**Item No.**                    **Report of the Head of Planning, Transportation and Regeneration**

**Address**                    1 CHEDDAR WAYE HAYES

**Development:**            Erection of a new attached dwelling, single storey rear extension to both existing and new dwellings and creation of vehicular crossover

**LBH Ref Nos:**            **76544/APP/2022/1451**

Drawing No. RA1490/REV A/02

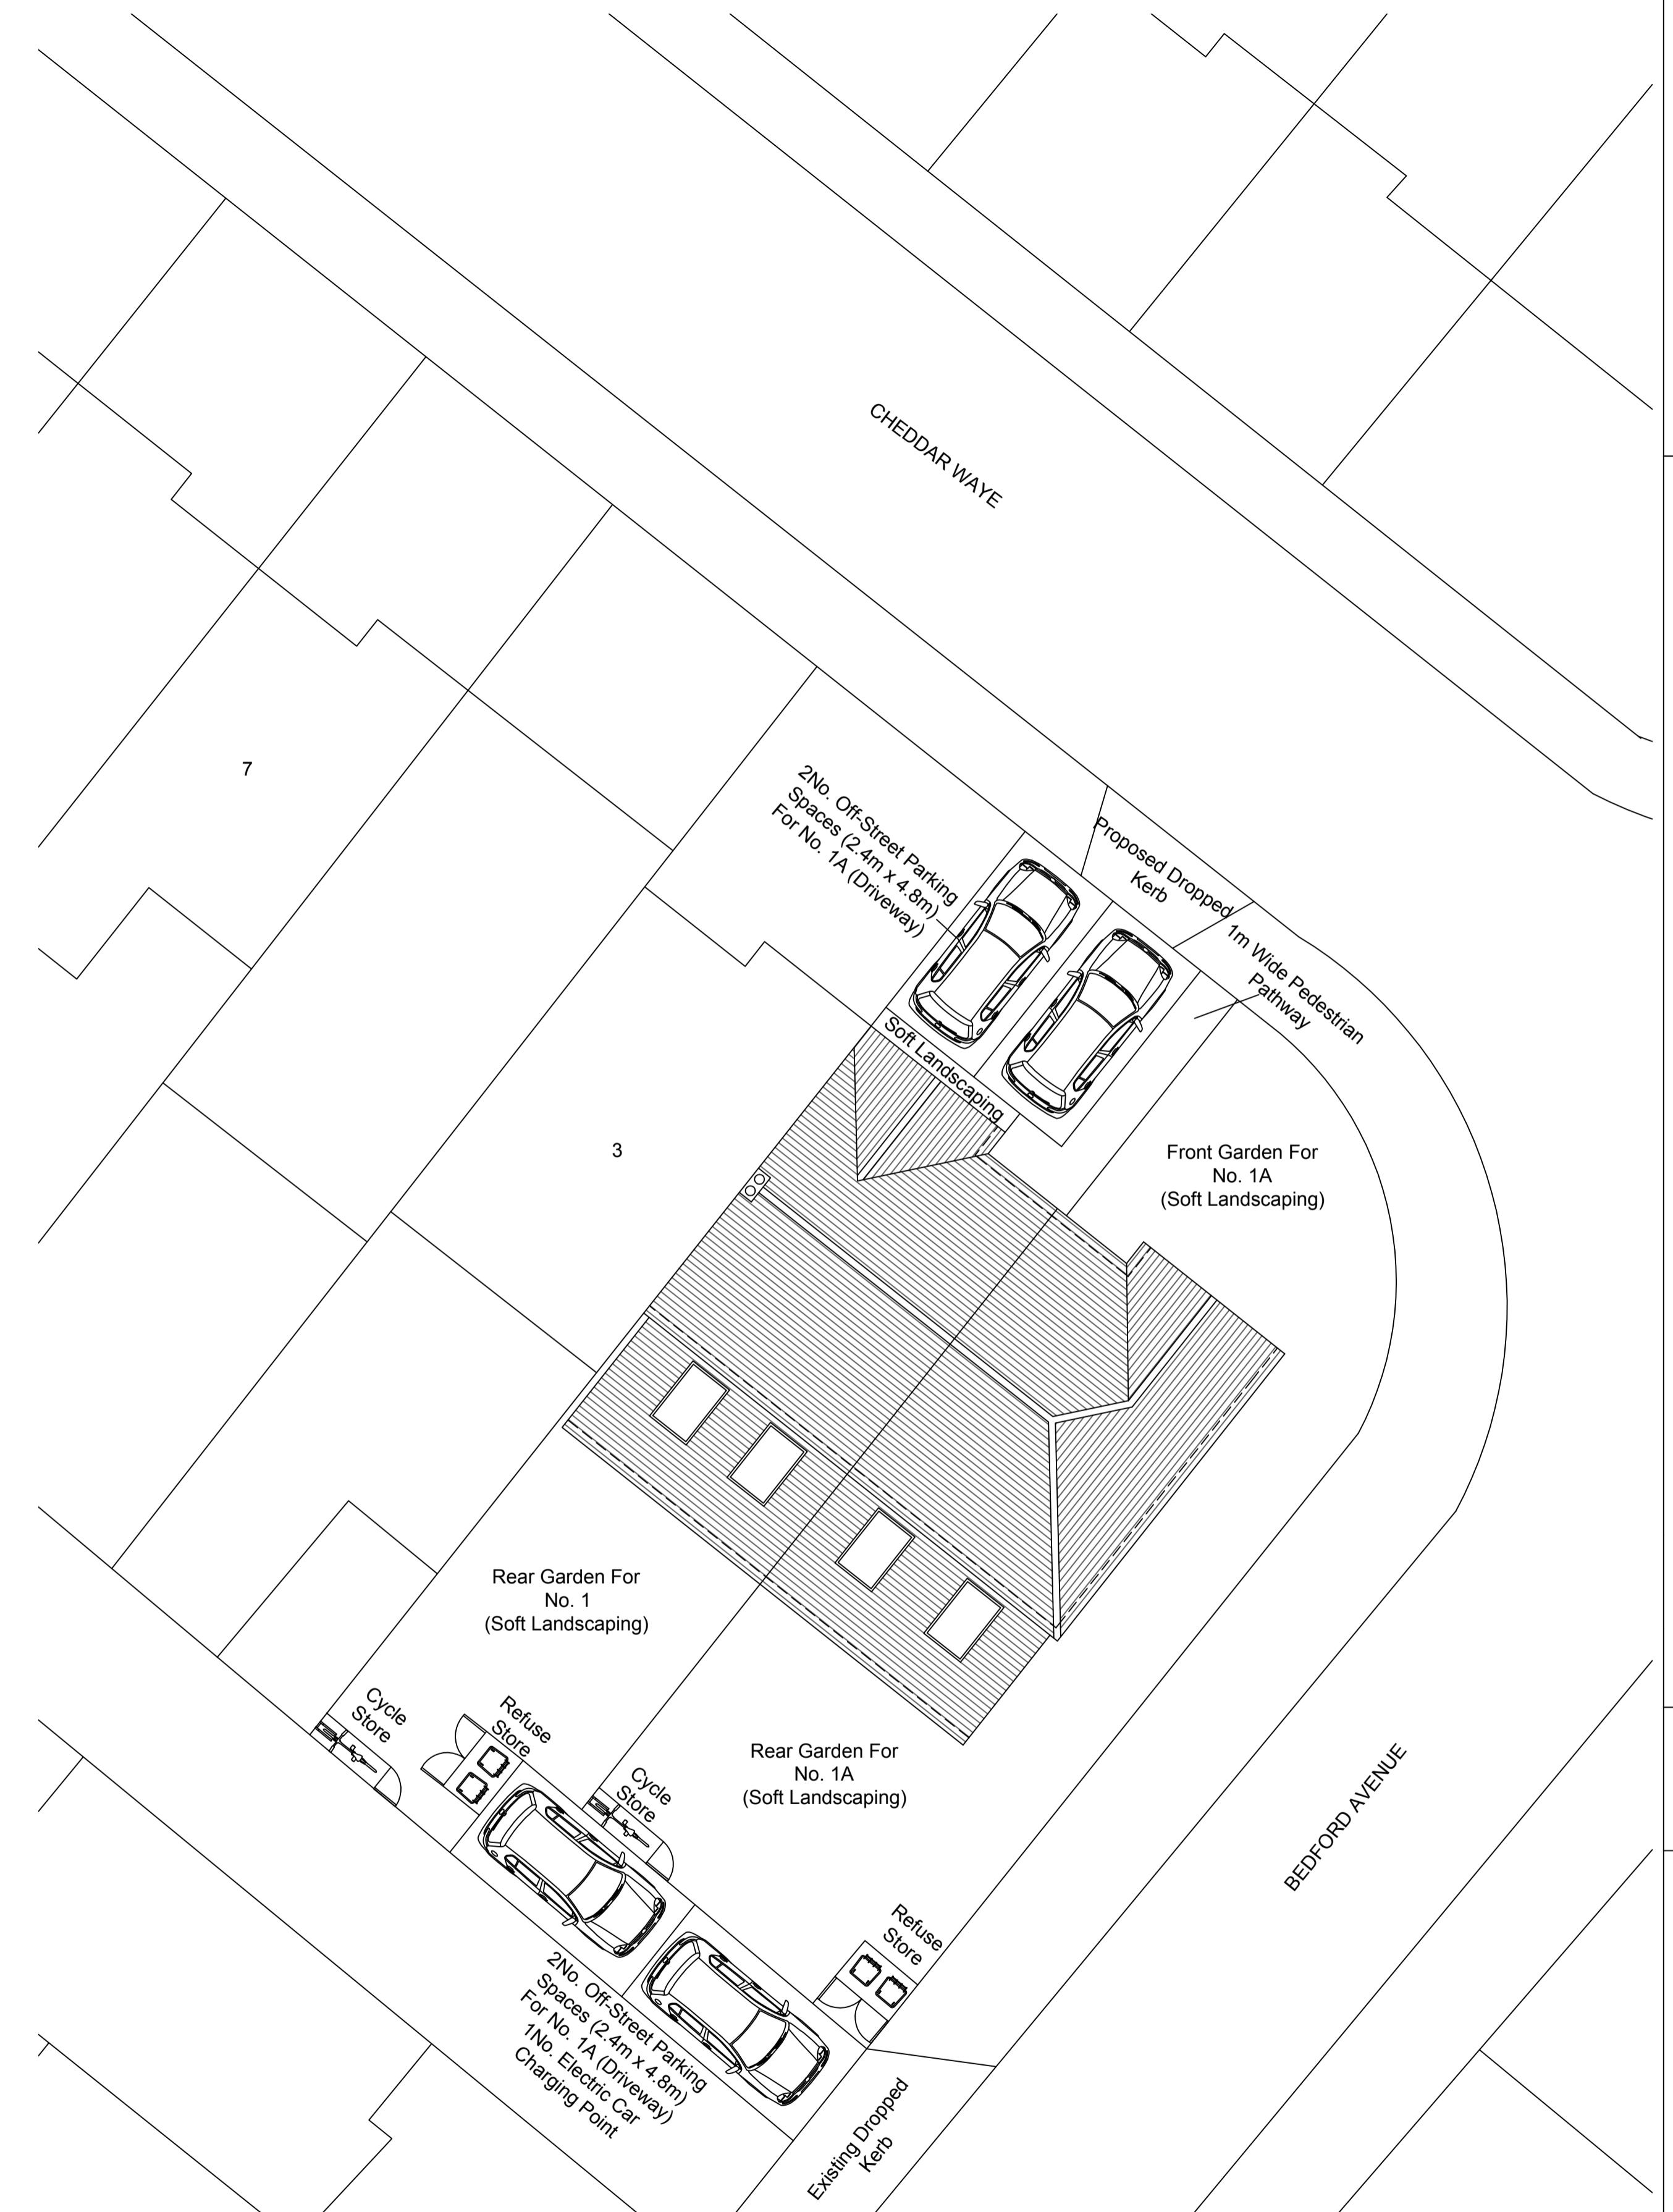
The application property has a large side garden area, which combined with the set back of the properties fronting Bedford Avenue and the large side garden of No. 1 Cheddar Way gives the appearance of significant spaciousness within its plot and makes a positive visual contribution to the appearance of the street scenes. The open space character and visual gaps also help to clearly define the end terraced context of the junction/corner property. The corner plot positioning of the application dwelling is such that it is visually prominent on both street scenes. The adjacent properties on Bedford Avenue to the rear have an established and uniform front building line and the front gardens and the side garden area of the application property results in a sense of spaciousness not only at the road junction but along the road. The proposed dwelling, at a width of some 0.35m narrower than refused scheme, would largely fill this spacious corner plot.

It is acknowledged that the property on the opposite side of Cheddar Way has been substantially extended to the side which has since been converted into a separate dwelling. Whilst the proposal would appear similar in scale to that opposite, the relationship the application has with the return building line differs given the distance is shorter. The proposal would cause material harm to the character of the area. The modest reduction in width of the property proposed by 0.35m is not considered to have materially affected the visual impact of the proposal previously refused.

The proposed development, by reason of it siting in this open prominent position, size, scale and bulk, would result in the loss of a substantial proportion of an important gap, characteristic to the area, which would breach the return building line and would be detrimental to the character, appearance of the street scene and the surrounding area. As such the proposal would conflict with Policies DMHB 11, DMHB12 and DMHD 1 of the Hillingdon Local plan - Part Two (2020) Policies D4 and D8 of the London Plan (2021) and the NPPF (2021).

The application proposes cycle and bin storage to the rear, accessed from the driveway serving 1A. The occupants of the host dwelling would not achieve independent access to the secure cycle storage and as such, the proposal fails to meet the Council's parking standards in conflict with Policy DMT6.

The retained dwelling would provide 43 square metres and the proposed dwelling 49 square metres, both of which fall short of the required standards. The applicant has justified the shortfall as being typical for a terraced dwelling within this area. Whilst it is acknowledged that some of the dwellings on this side of Cheddar Waye have similar sized gardens, this is not justification for such a stark departure from the Council's planning policies. The wider area is typified by terraced houses with larger rear gardens and high quality design is required for new homes in the Borough. The benefit of one home does not outweigh this, particularly given the other issues identified.

It is noted however that the entire frontage of the host dwelling would be laid to hardstanding for the parking with the exception of a narrow strip of soft landscaping adjacent to the front wall. Due to the proposed siting of the off street parking bays and direct pedestrian access for the existing dwelling, it is considered this would result in a large area of hardstanding/parking on this frontage, and would not allow sufficient space to mitigate this impact by way of soft landscaping. The applicant justifies this shortfall of soft landscaping as being in keeping with the character. However, the frontage is currently laid to soft landscaping and its entire loss cannot be justified. The proposal would therefore be detrimental to the visual amenities of the street scene and character and appearance of the wider area, contrary to Policy BE1 of the Hillingdon Local Plan (November 2012); Policies DMHB11, DMHB12 and DMHB14 of the Hillingdon Local Plan -

Drawing No. RA1490/REV A/01

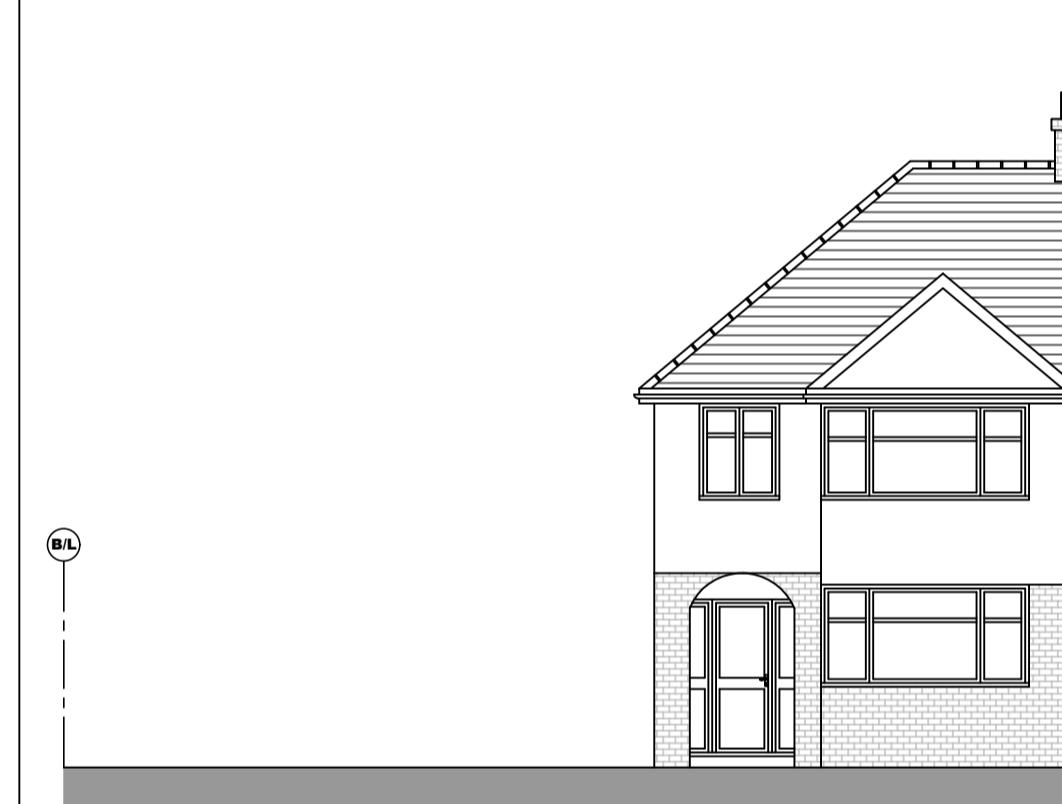
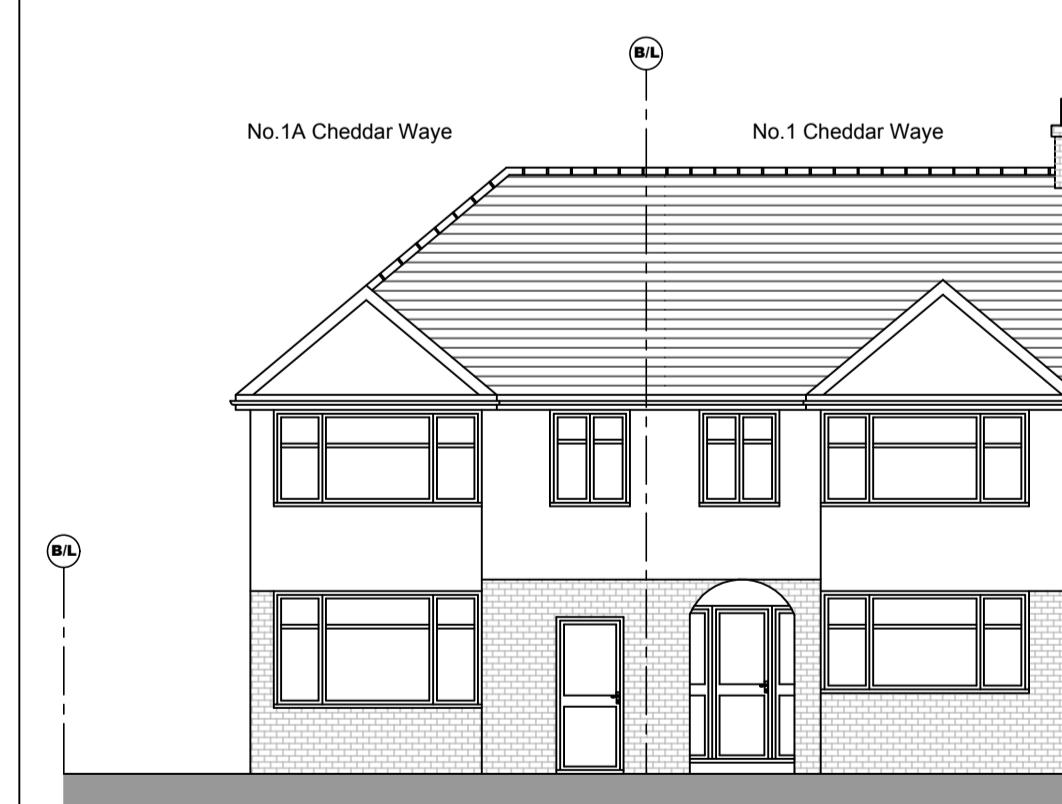
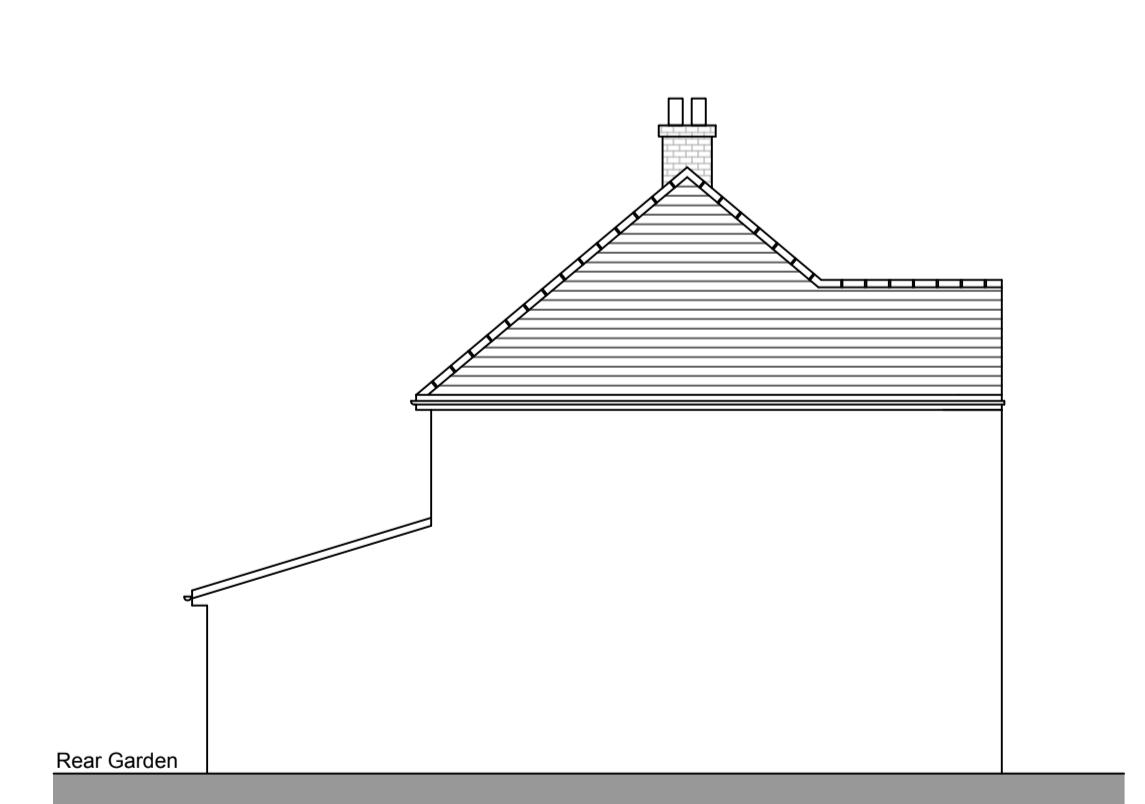
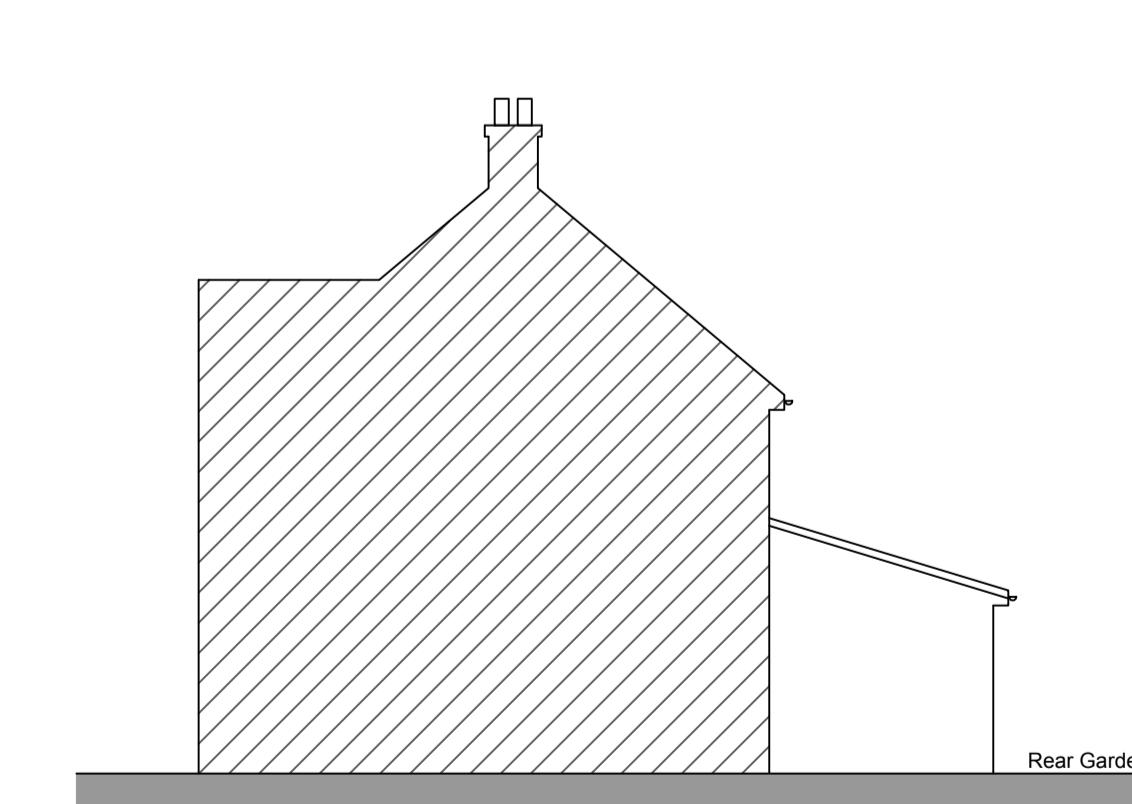
At 84.5 square metres, the proposed dwelling would meet the minimum standards. The internal floorspace has been amended to address the concerns with regard to living environment raised in the previous application. The internal living accommodation is considered to present a satisfactory living environment in accordance with Policy D6 of the London Plan (2021).
